December 14, 2018
File: PE4194-LET.03

Subject: **Response to Site Plan Comments**
City File No. D07-12-17-0173 and D02-02-17-0126
Re: Phase II ESA
443 and 447 Kent Street and 423-425 McLeod Street
Ottawa, Ontario

DRAWING PE4194-3 – TEST HOLE LOCATION PLAN

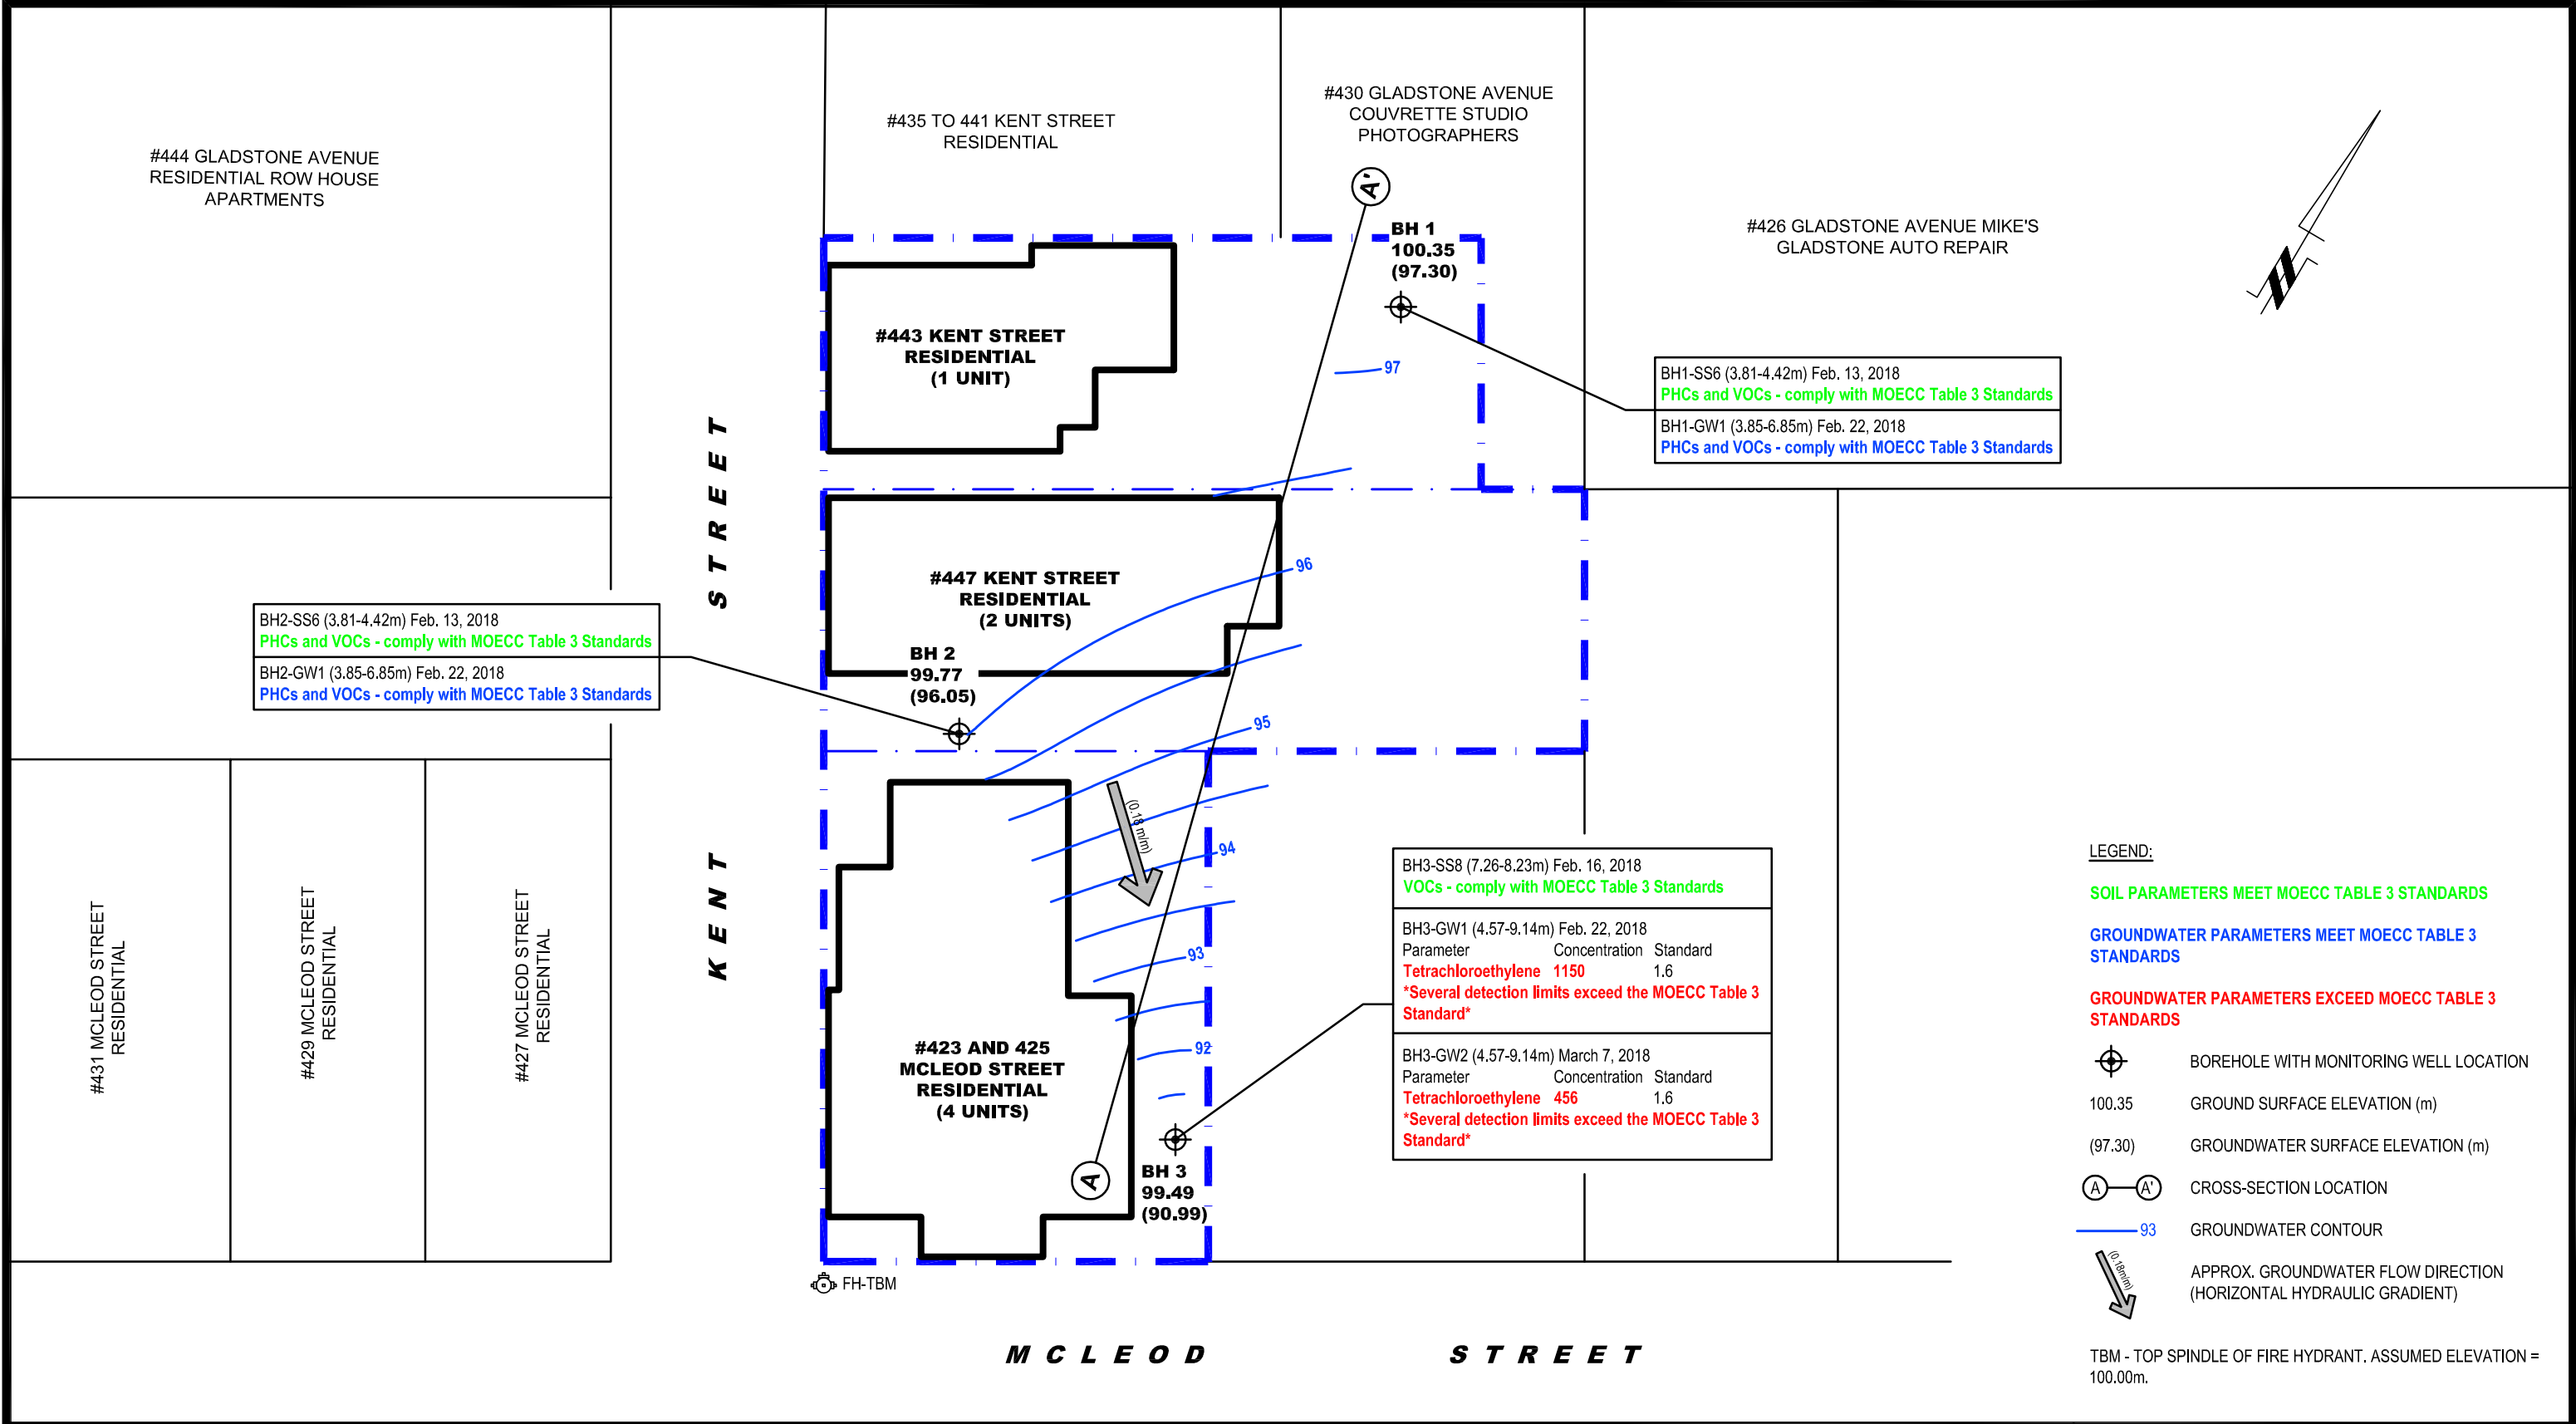
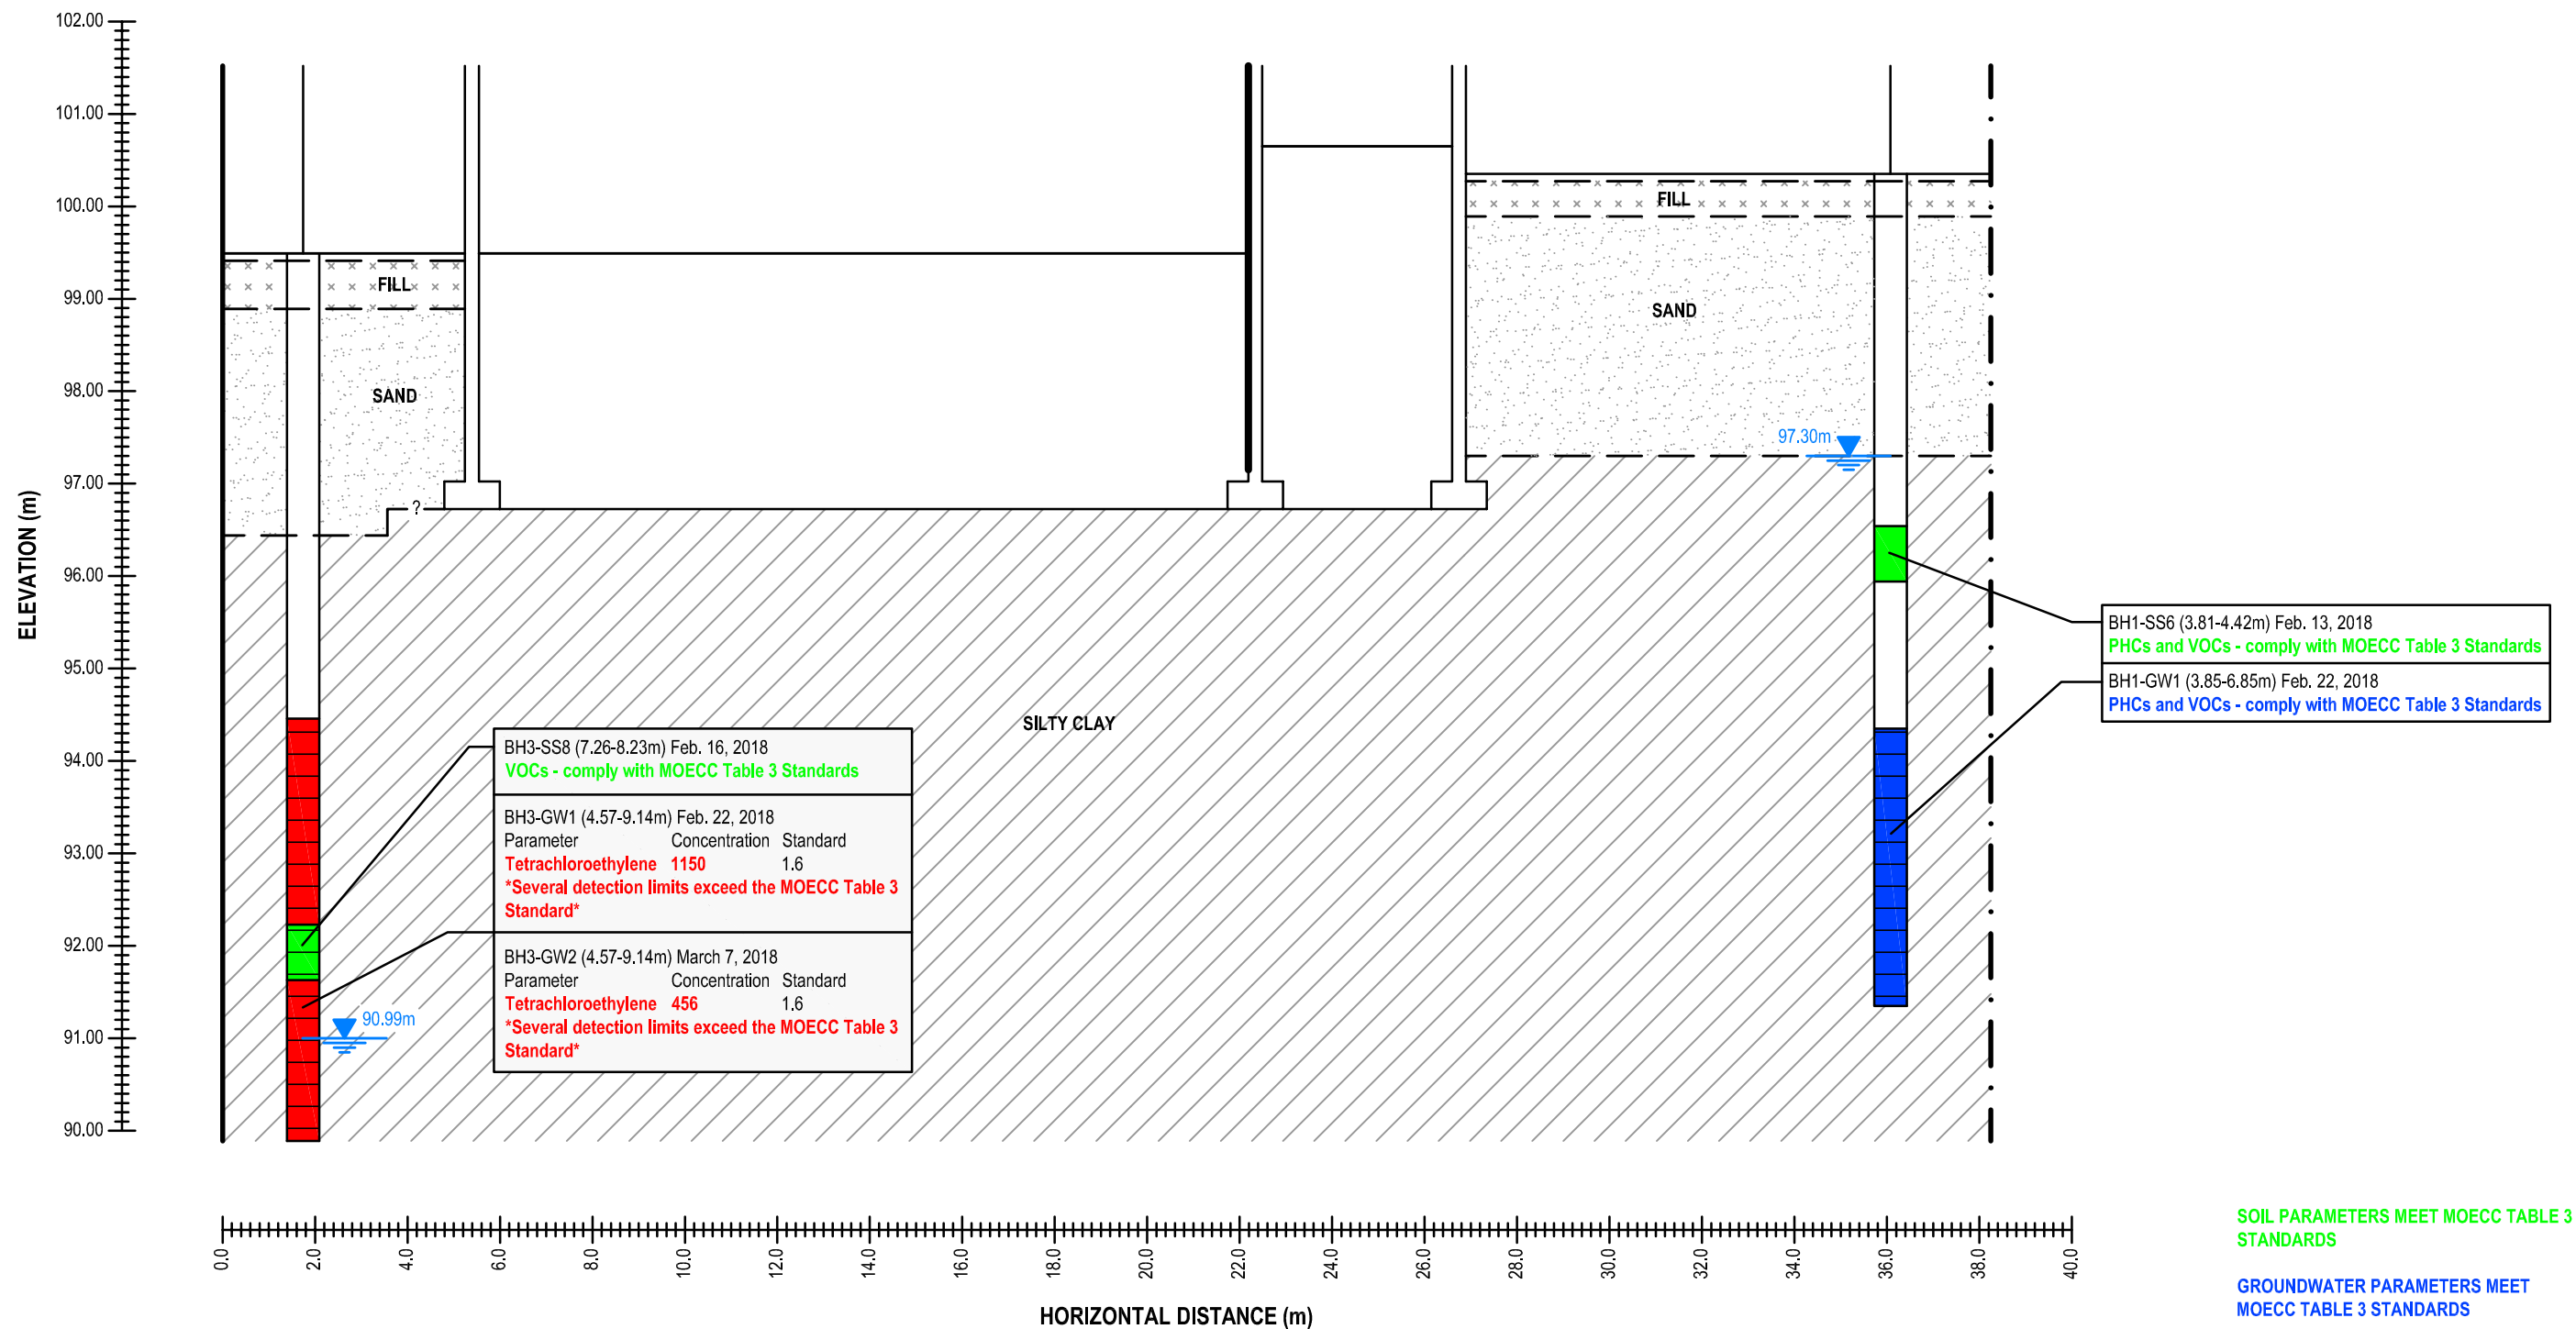
1. Additional boreholes have not been completed for the subject site at this time, as discussed below.
2. The attached test hole location plan has been updated to include two additional sampling events for BH3 since issuance of the Phase II ESA. The concentration of Tetrachloroethylene has dropped significantly since the previous testing in March 2018 and is in compliance with the MECP Table 3 Fine-Grained Standards, but remains marginally in excess of the MECP Table 3 Coarse-Grained Standards. No other VOC parameters were identified during the additional testing with the exception of chloroform, which is in compliance with the applicable MECP Table 3

Standards. Based on the most recent VOC results from BH3, the original test results are not considered to be representative of the actual groundwater quality.

The supplemental groundwater monitoring has also provided new information with respect to the groundwater flow direction. Based on the recent groundwater depth measurements, the groundwater flow direction is towards the west, which suggest that the source of contamination is not the site.
